November 5, 2012

**Re: Sawmill Crossing Grading and Drainage Plan  
Engineers Revised Stamp Date 11-5-12 (H-13/D057)**

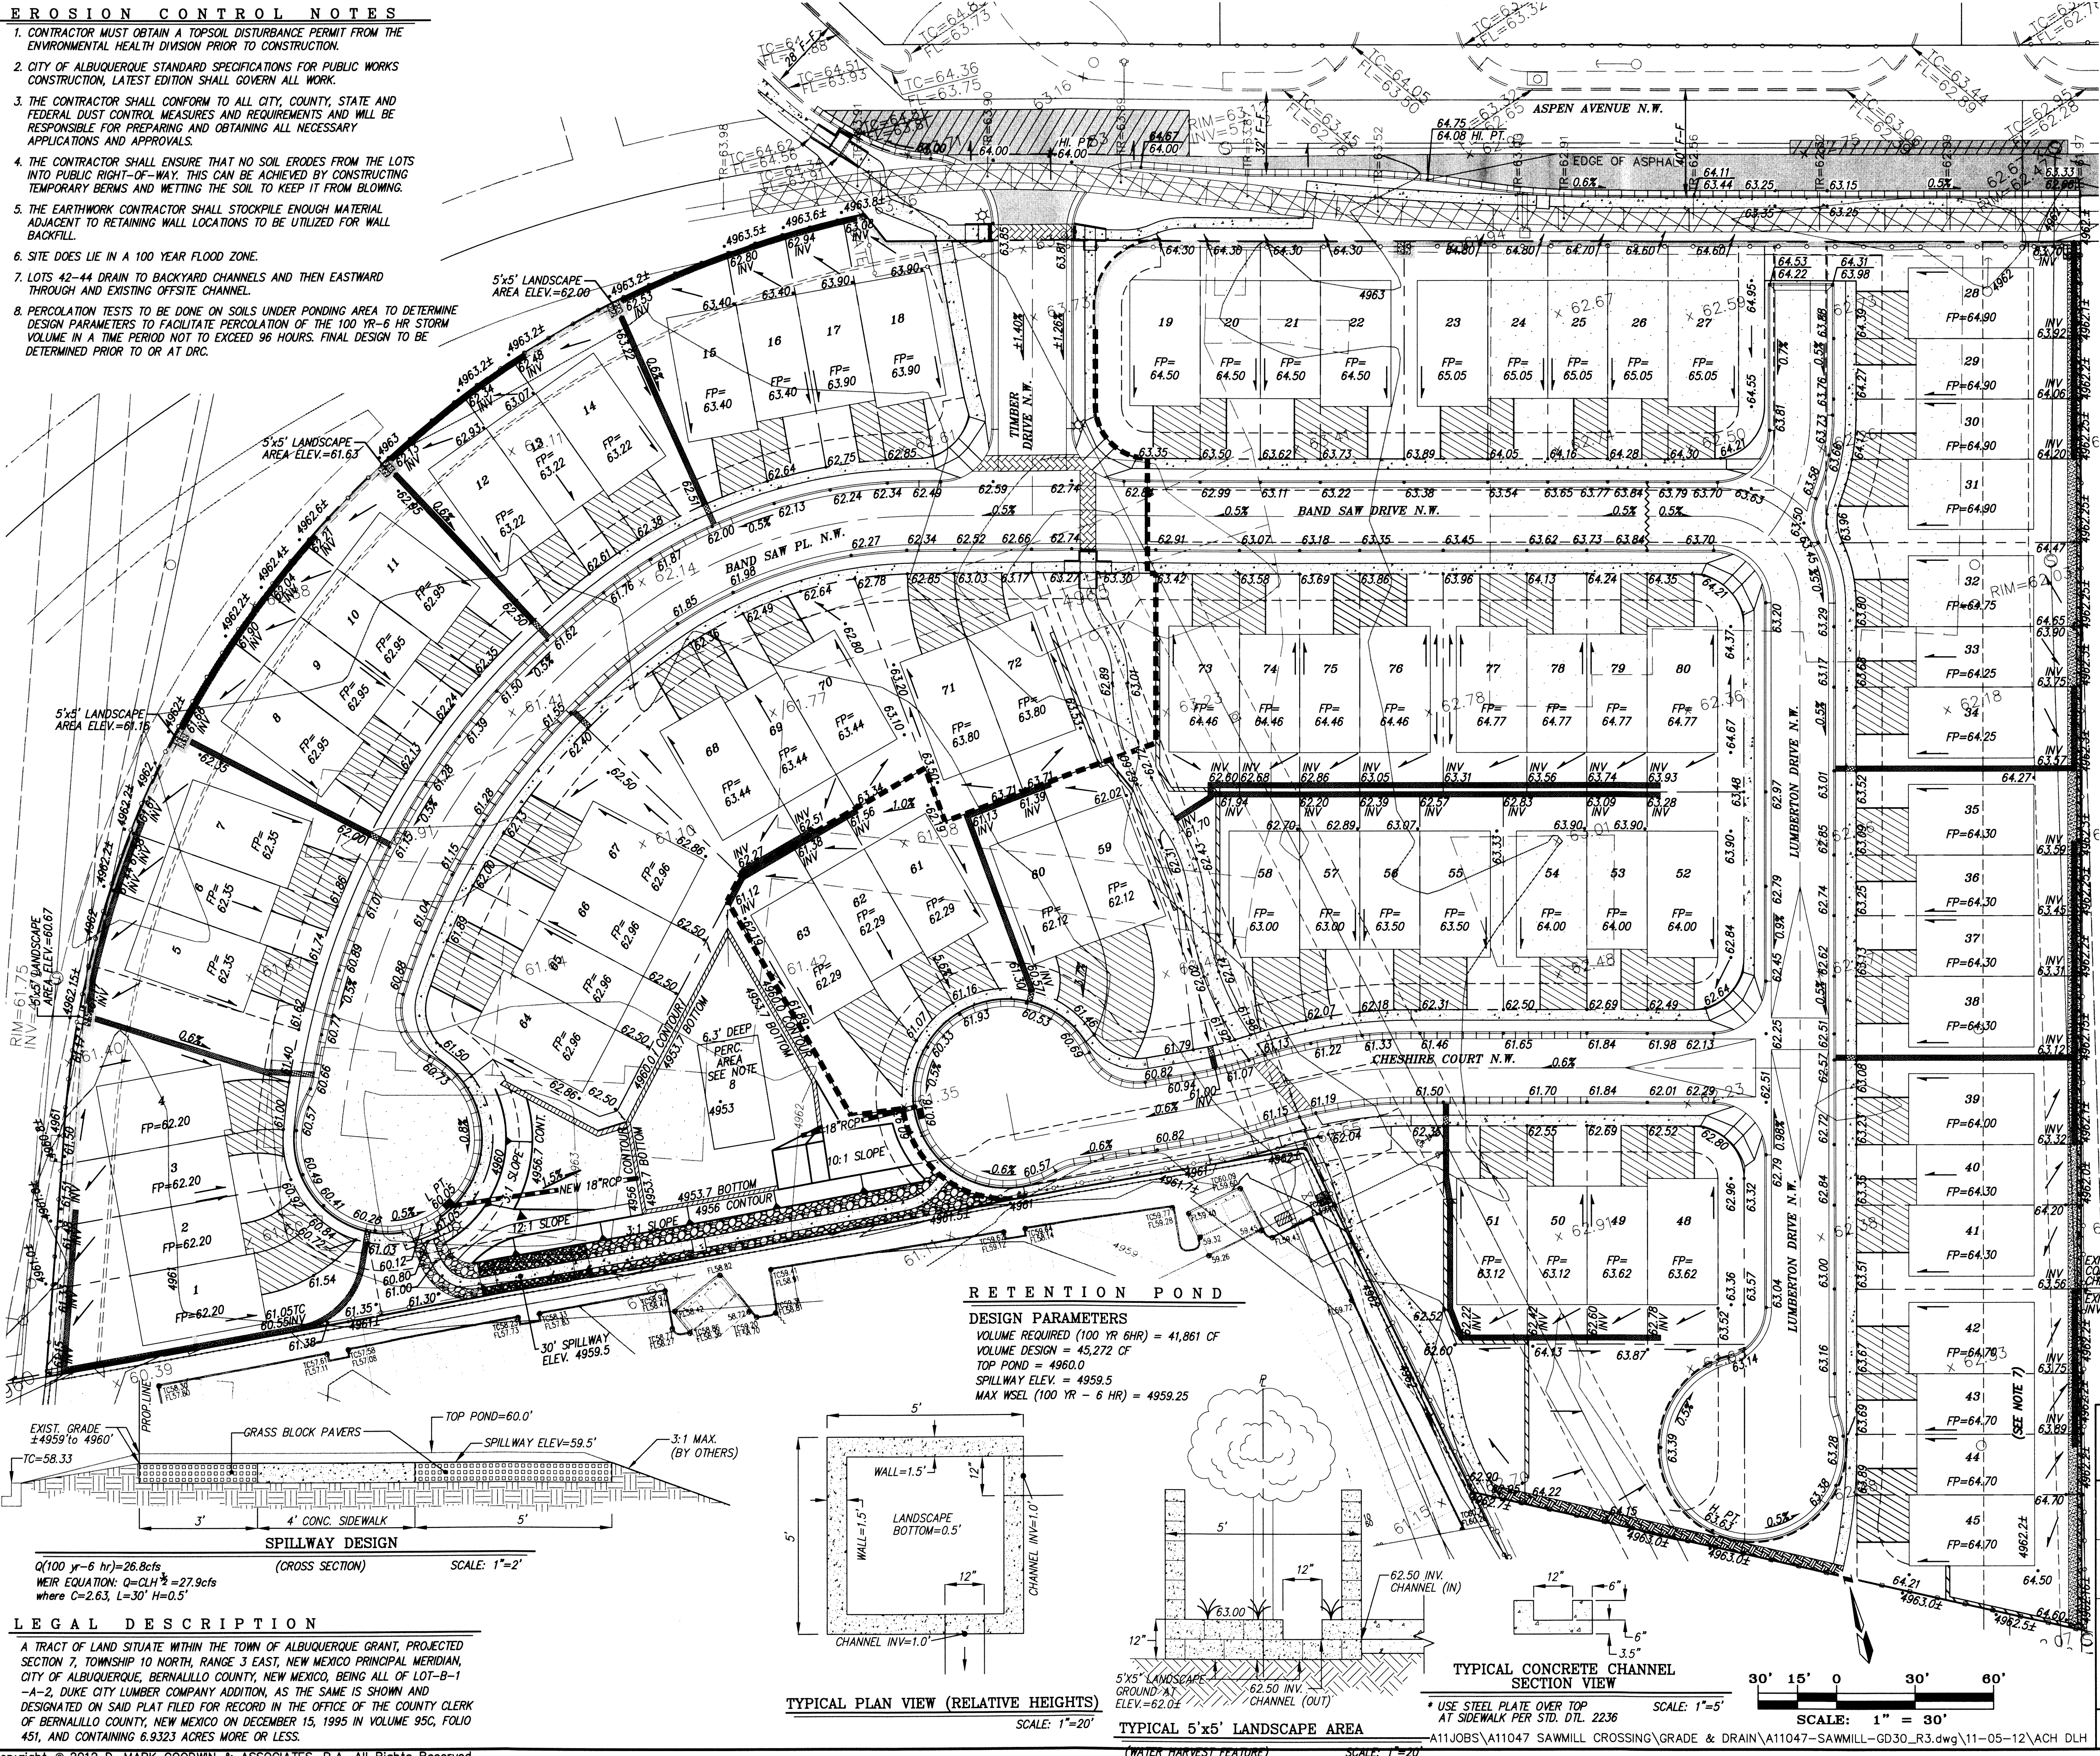
In response to several comments made at DRC about the sidewalk around the Band Saw Place cul-de-sac, I am resubmitting the grading and drainage plan to provide more elevation information on the area behind and south of the cul-de-sac. I also called for grass block to be placed on each side of the spillway.
